## **Planning Comments – 1210 Brighton**

Sheet Title:  
**LANDSCAPE AND LIGHTING PLAN**

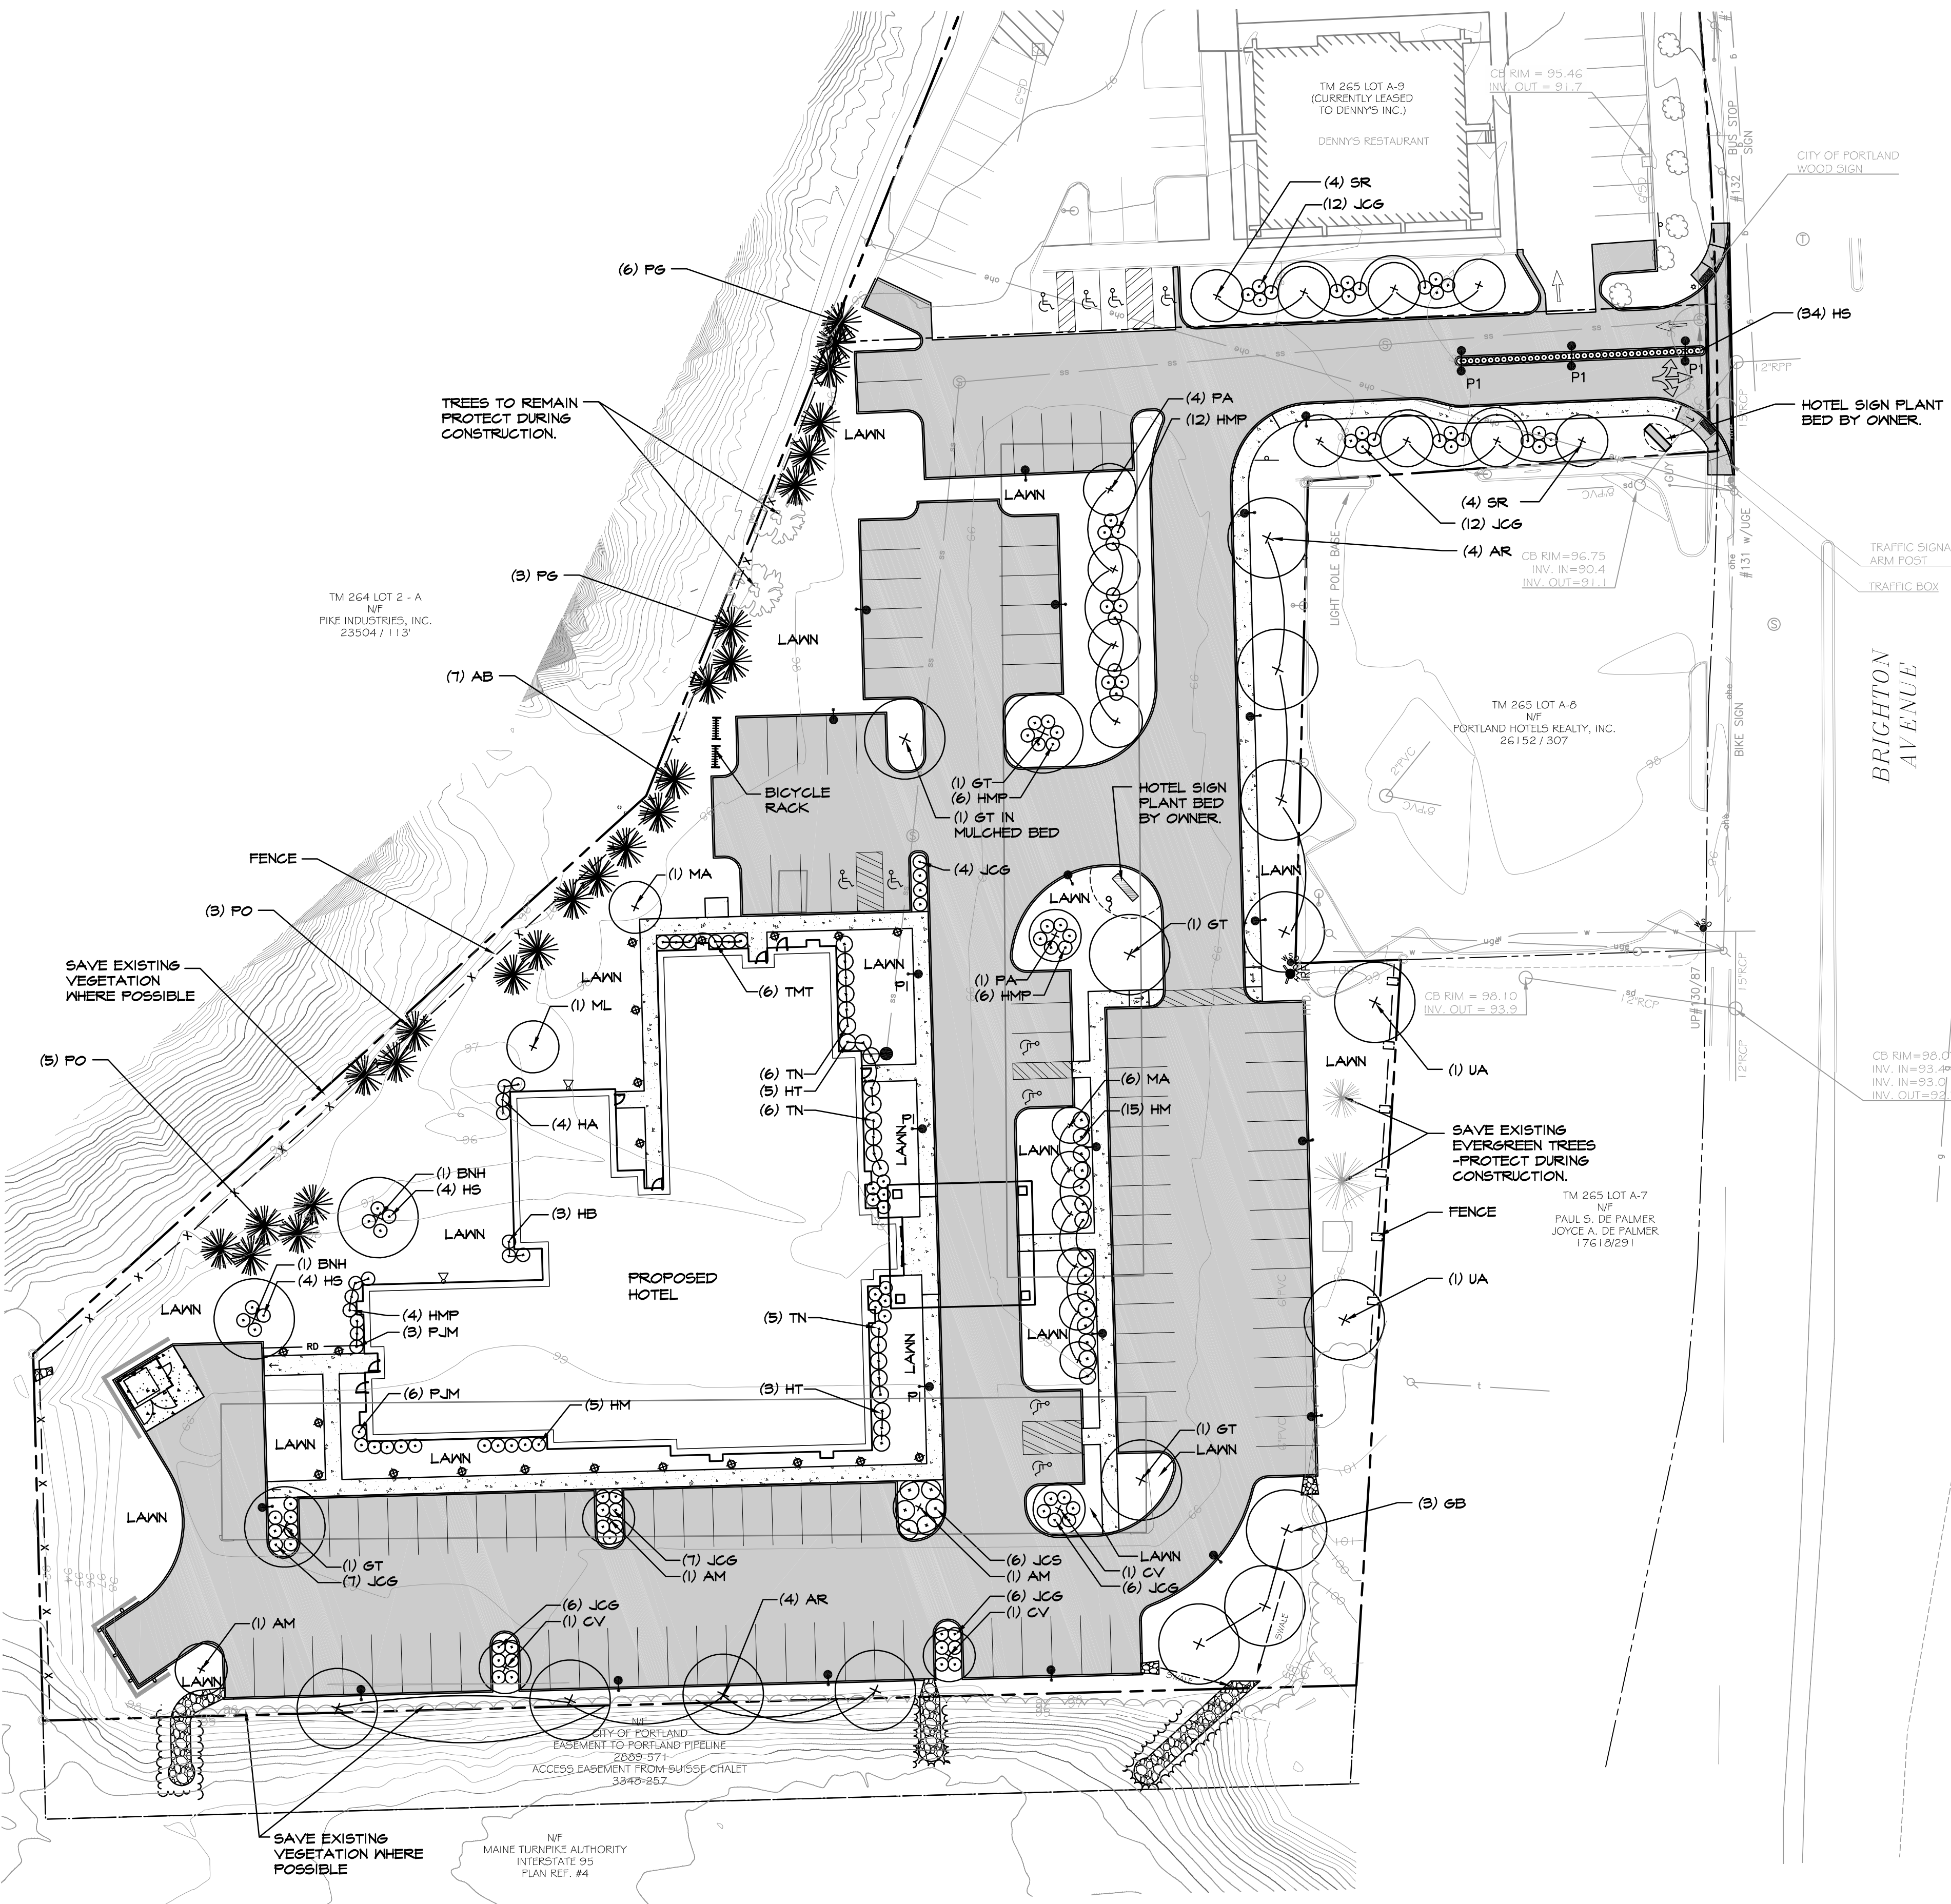
- Please consider preserving more of the mature maples, as well as the existing evergreen trees at the front of the site.
- Please confirm that the landscaping plan meets the understory planting requirement of 6 shrubs/45 LF of frontage (14-526(b)2b(i)(b)).
- The drainage plan shows corrugated metal pipes on city property to east which will take runoff from the parking area on the eastern side of the site. Please verify that these pipes are in sound condition.

Sheet Title:
PHOTOMETRIC PLAN

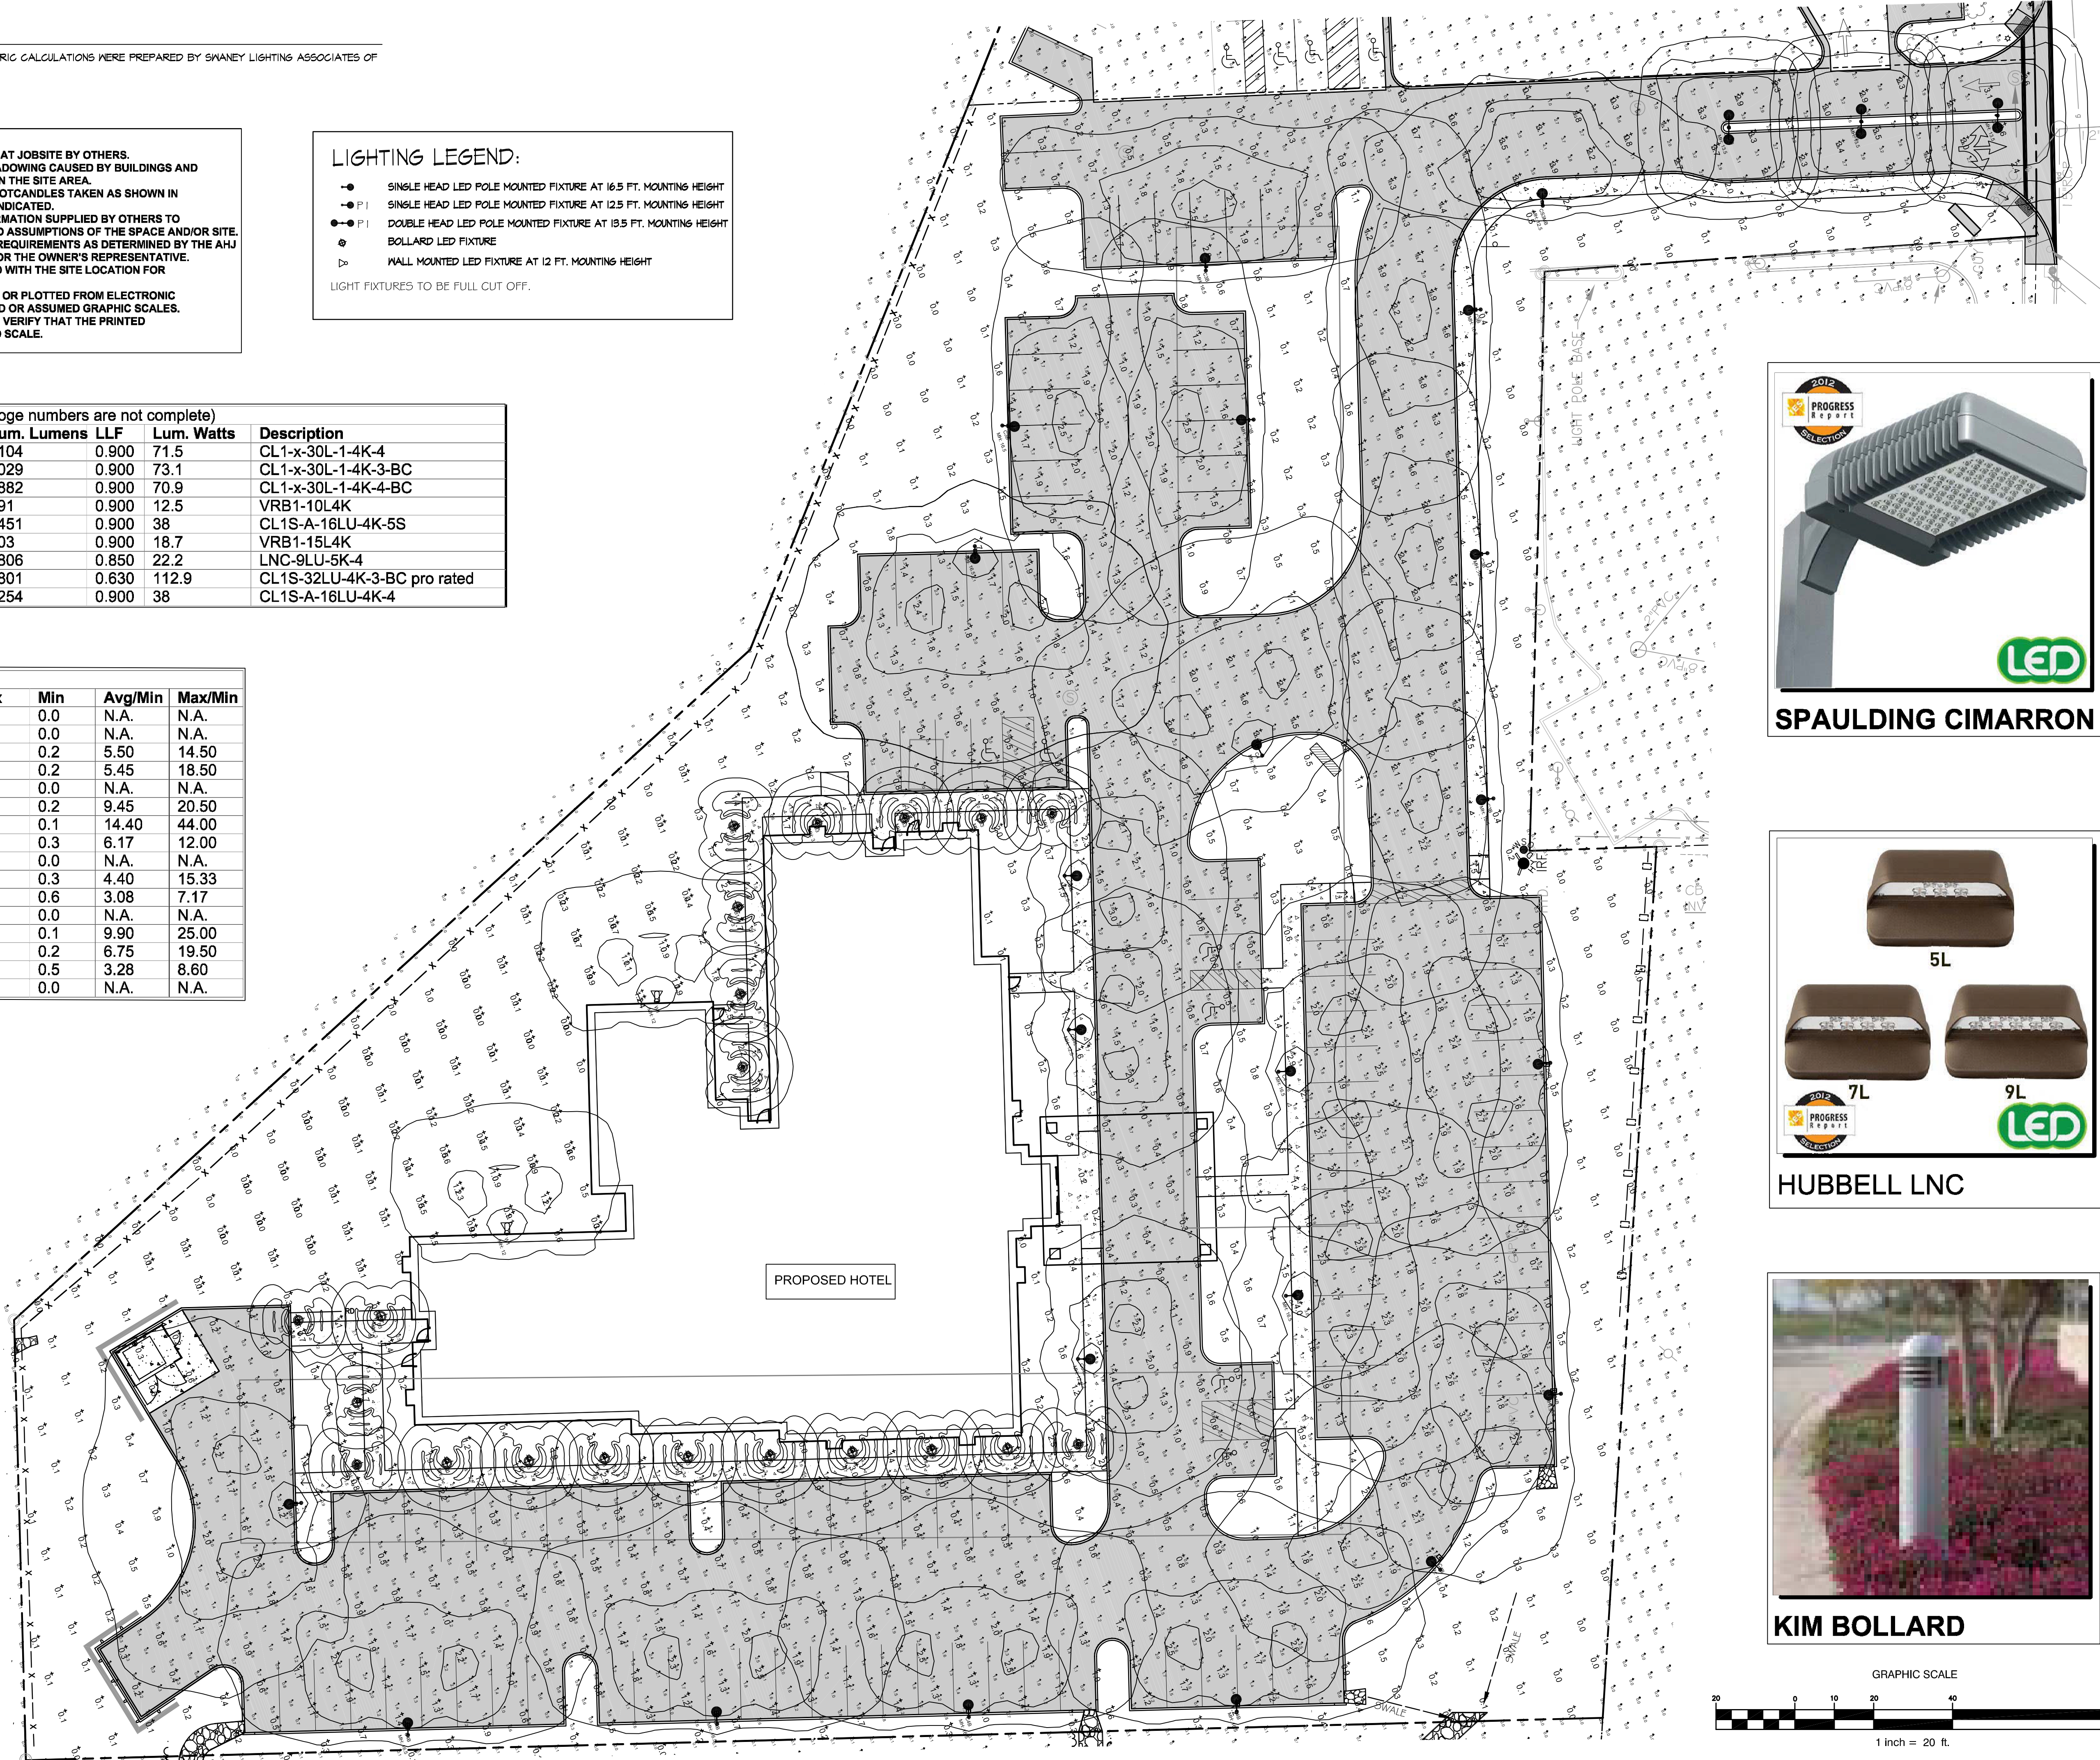
- Please provide lighting specifications and a photometric plan in the revised submittal.
